Please ask for: Ms Iqraa Malik
Email: iqraa.malik@terraquest.co.uk
Telephone: 0121 234 1390
Our Ref: PO/11/21/HH
Your Ref:
Date: 13th October 2021

Application for Planning Permission for Works or Extension to a Dwelling

Development: Erection of single storey side and rear extension, replacement garage building following the demolition of existing rear extension. Repair and reconstruction of the roof structure, associated landscape works and external alterations.
(This application may affect the setting of a listed building)

Location: St Johns Cottage Poling Street Poling BN18 9PS

EAST ELEVATION
1:50

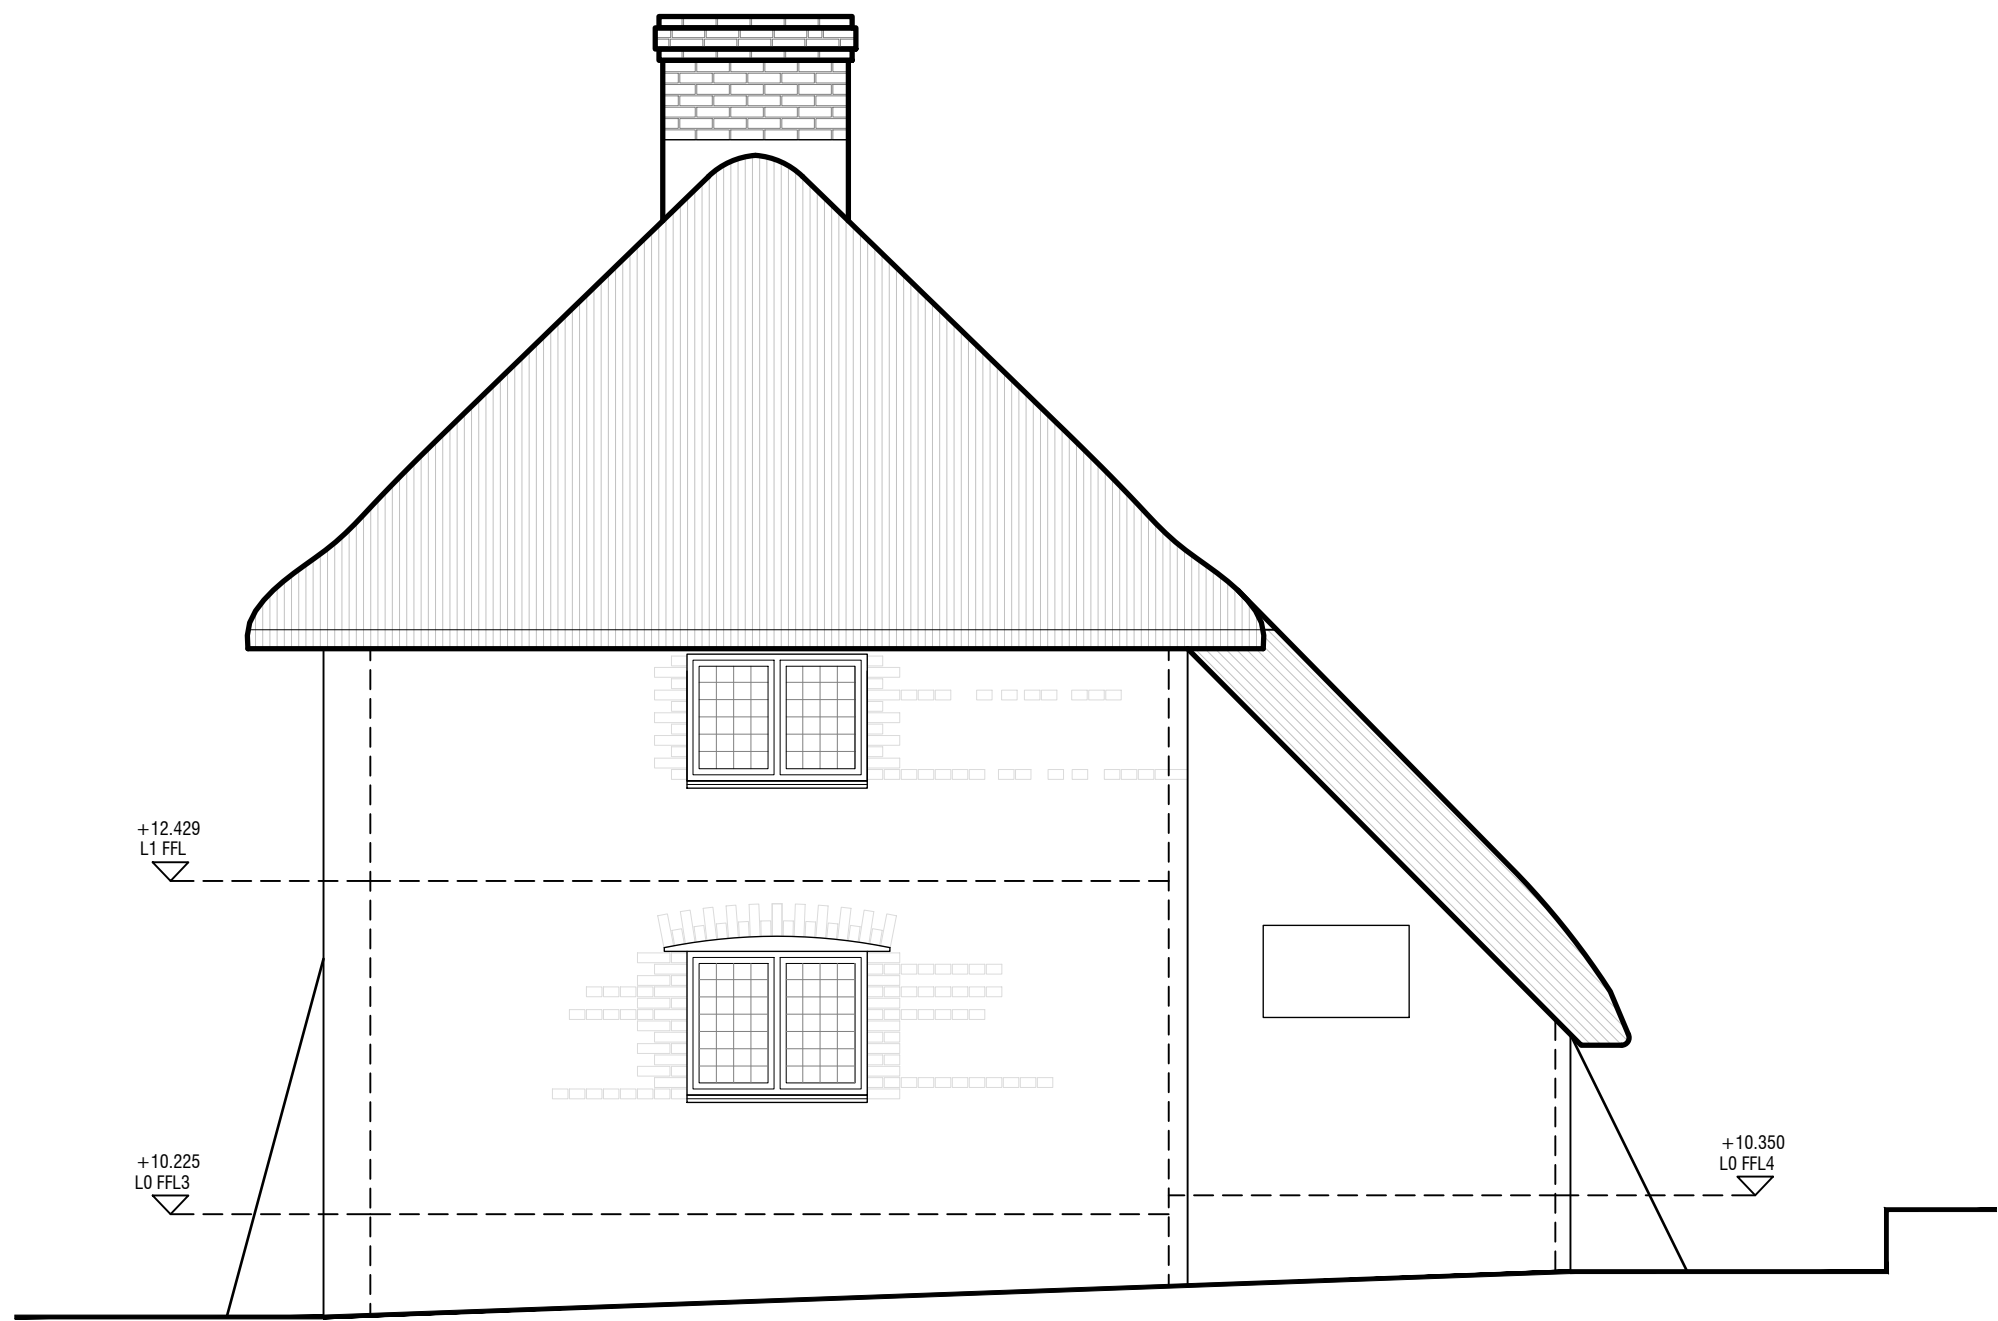
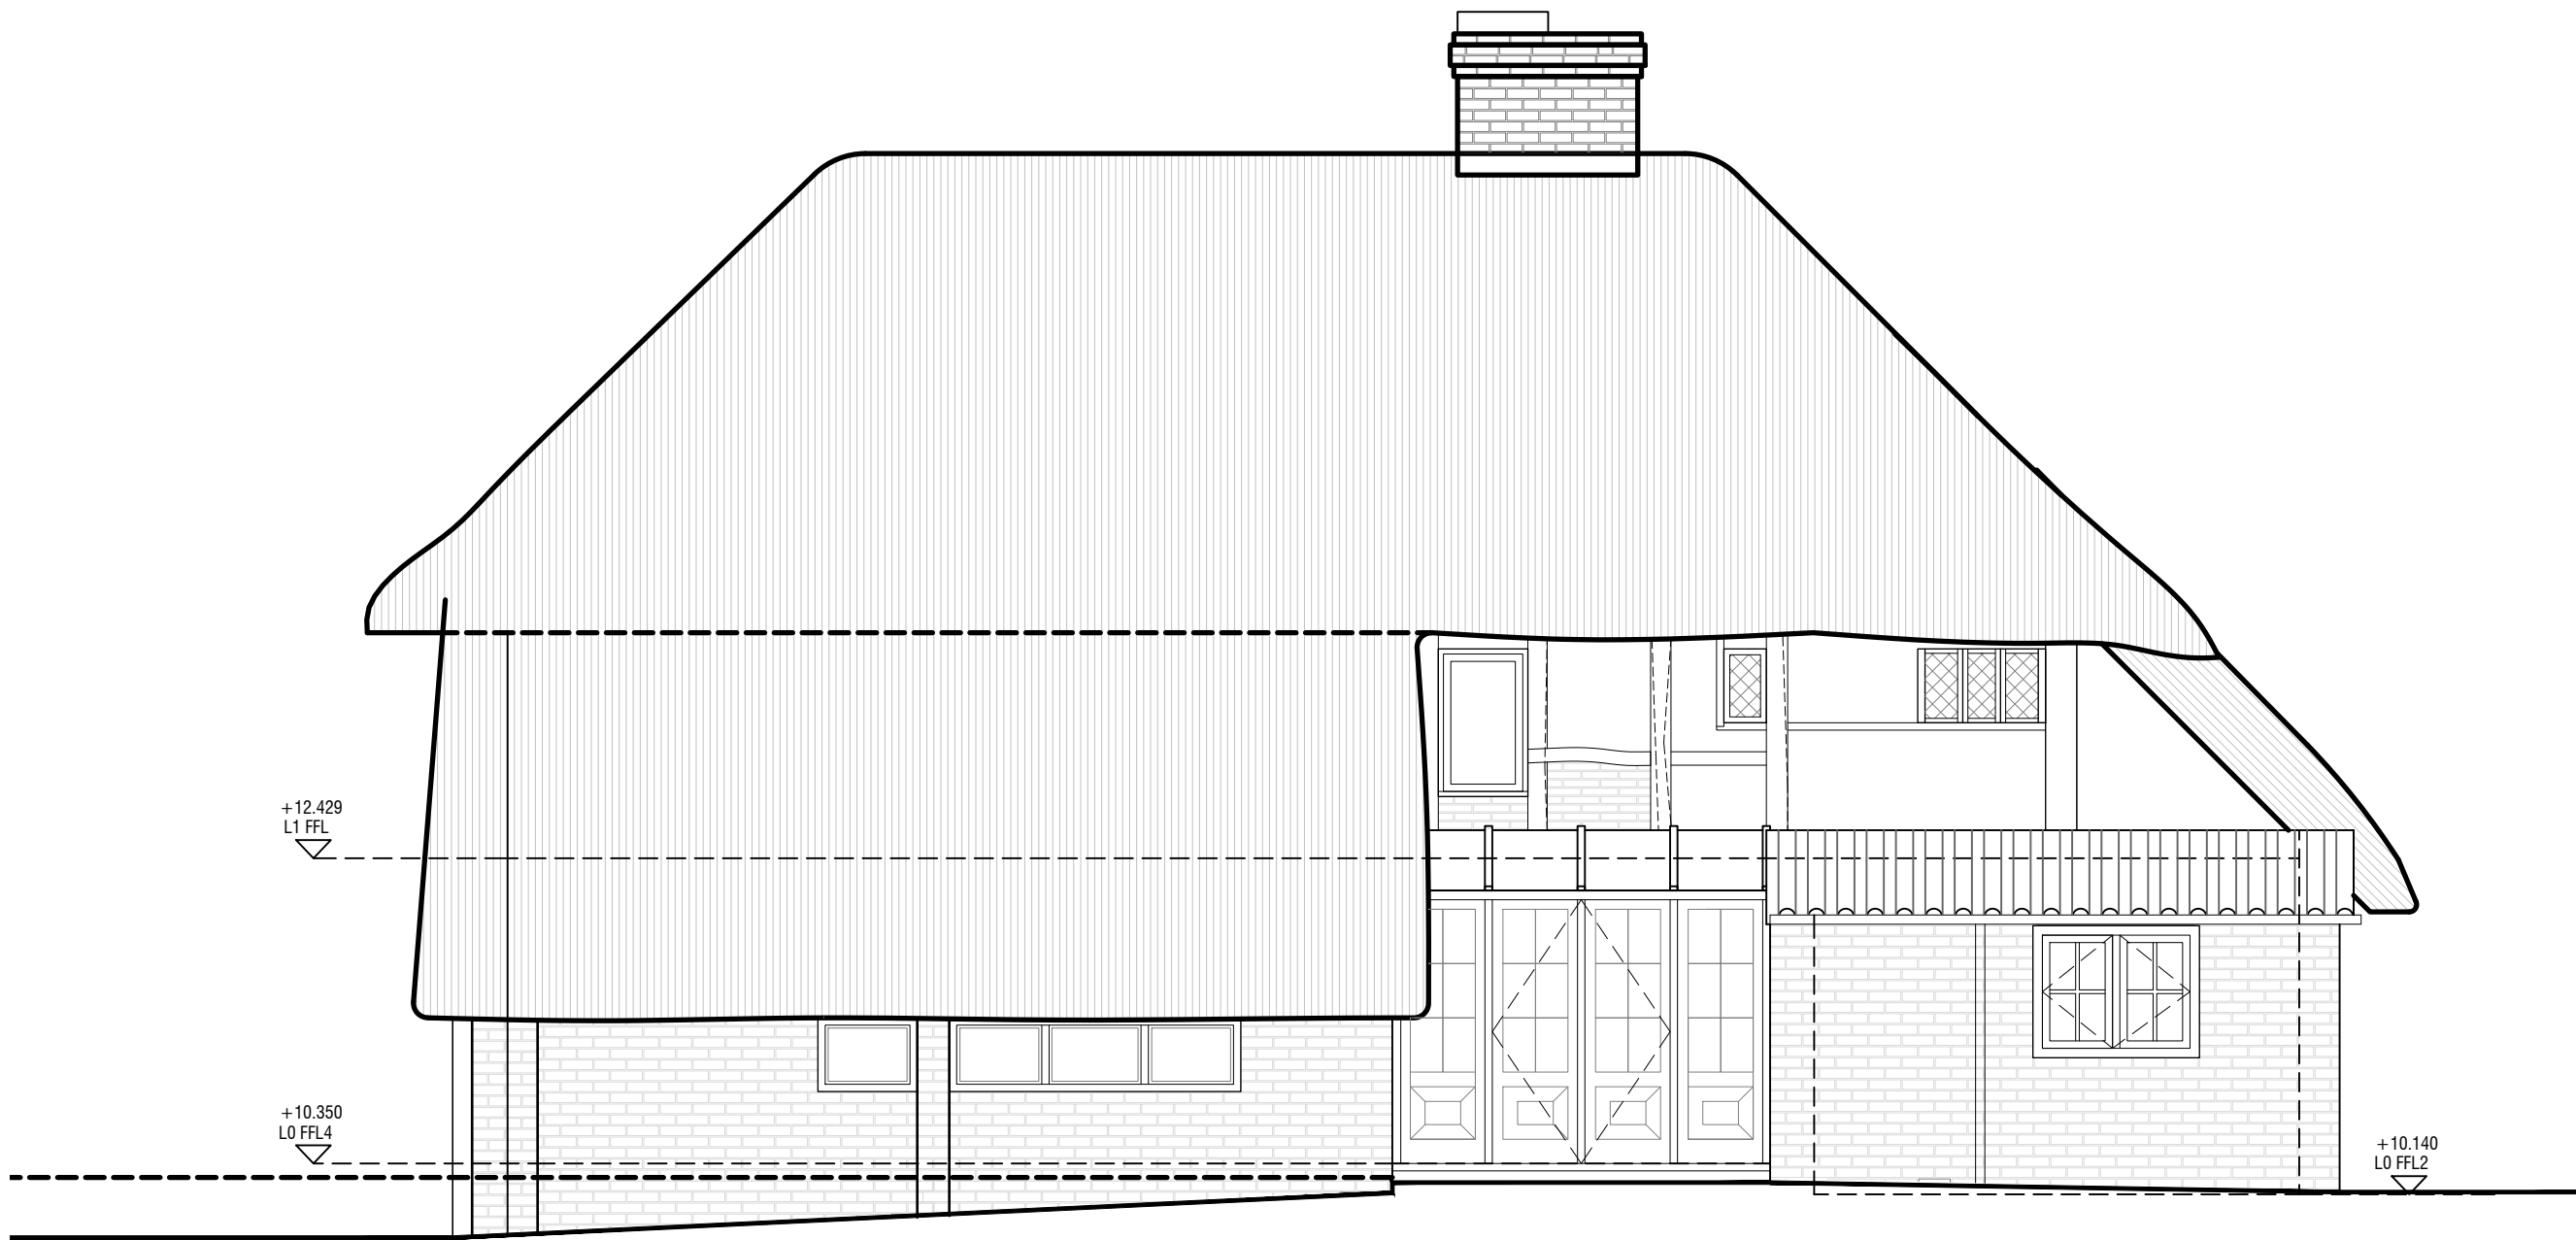
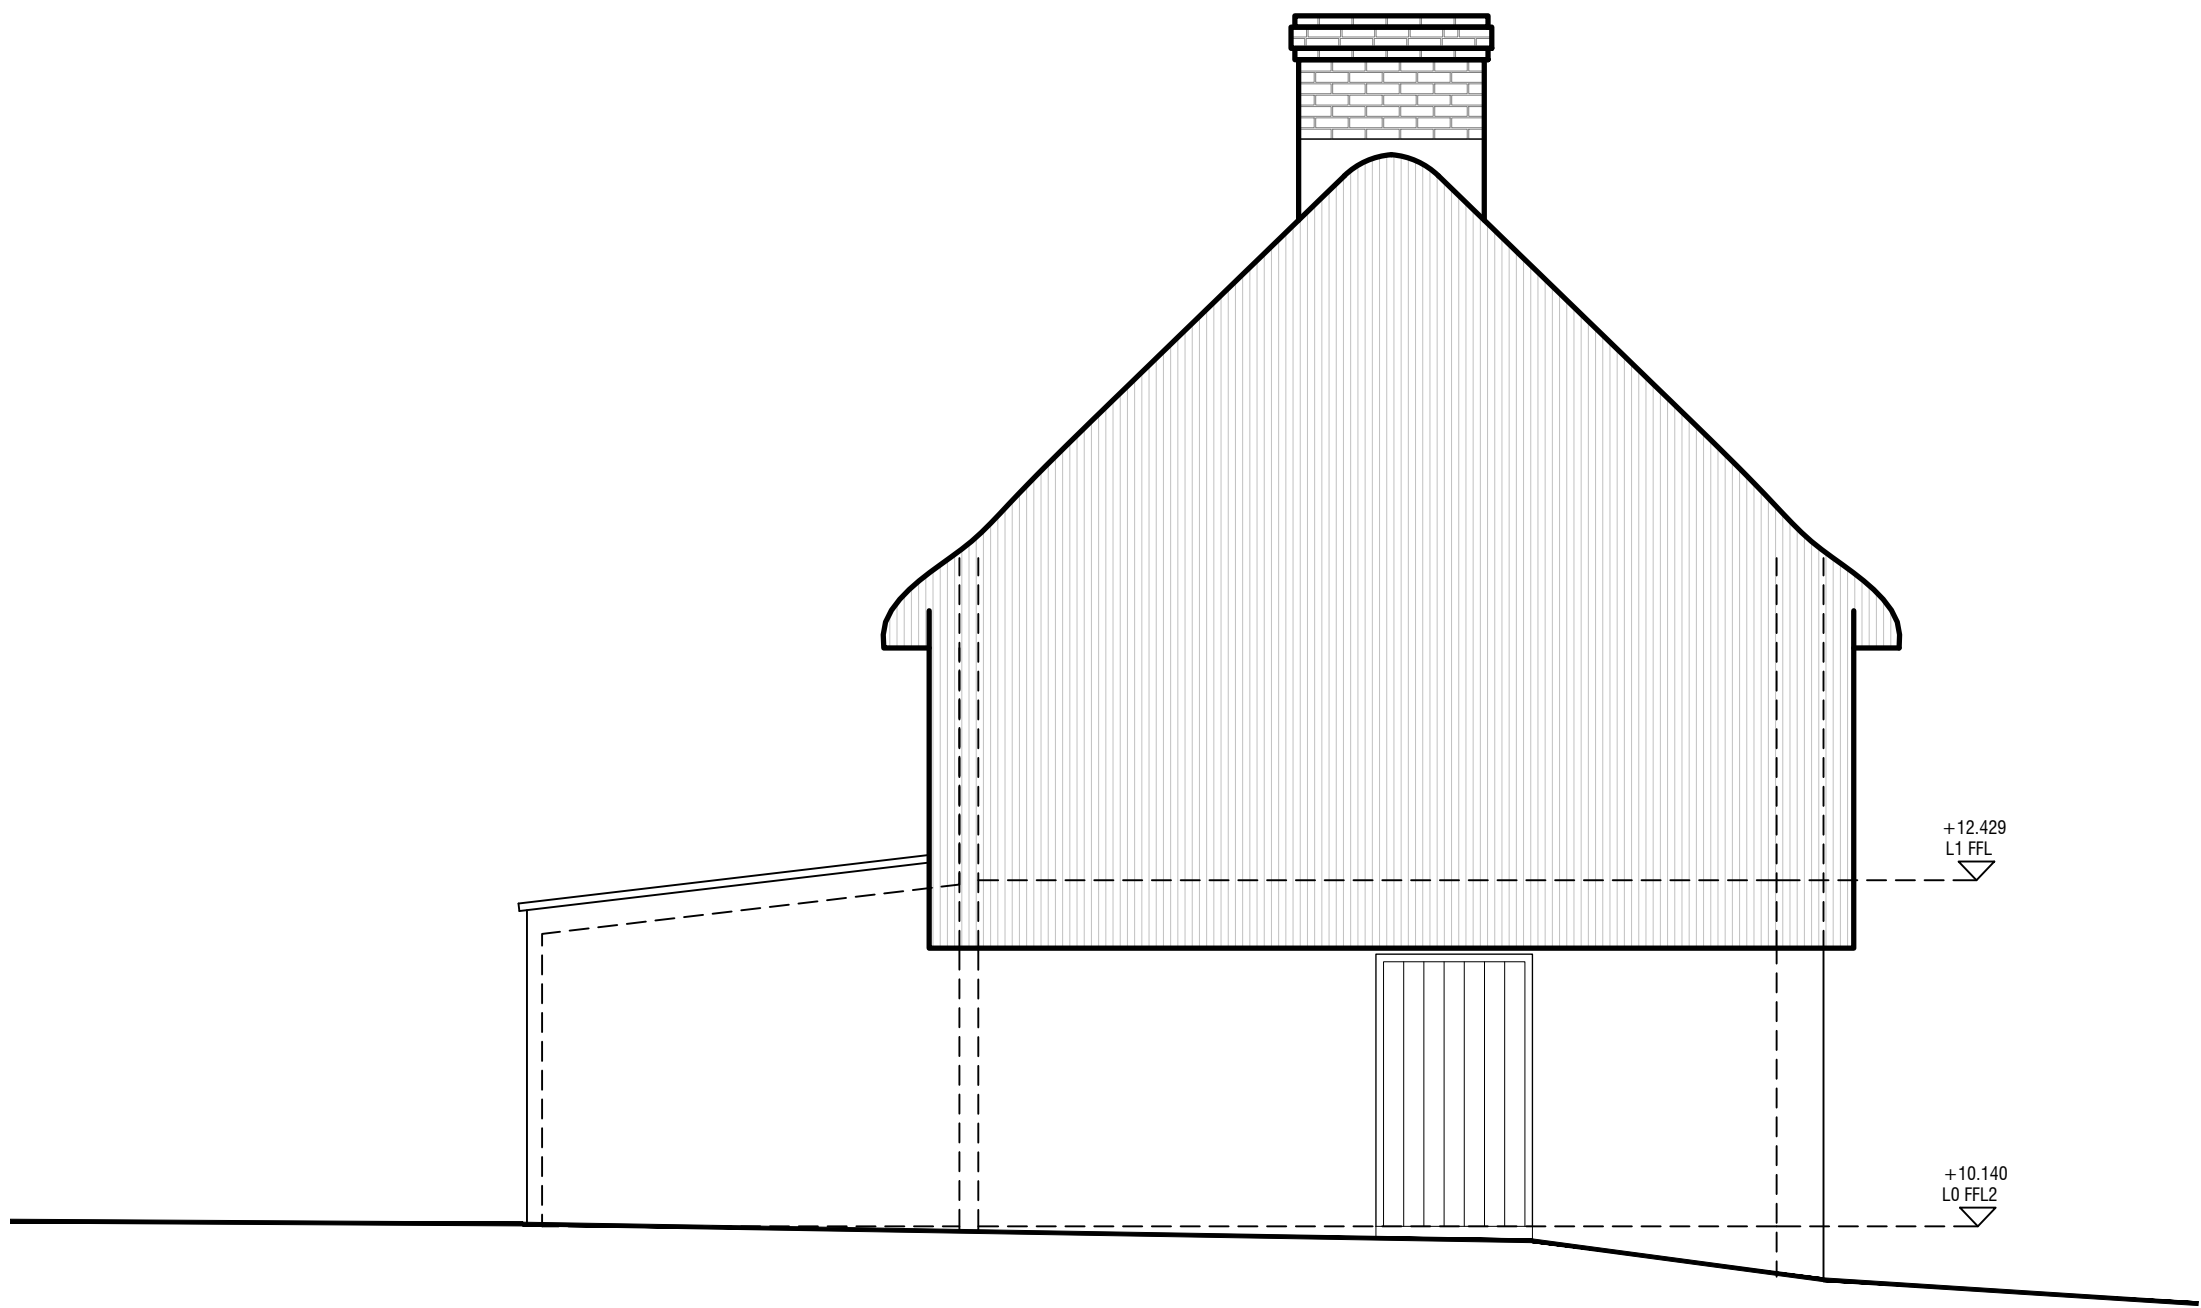
Elevations

The existing east elevation is labelled as west elevation. Please review and amend.
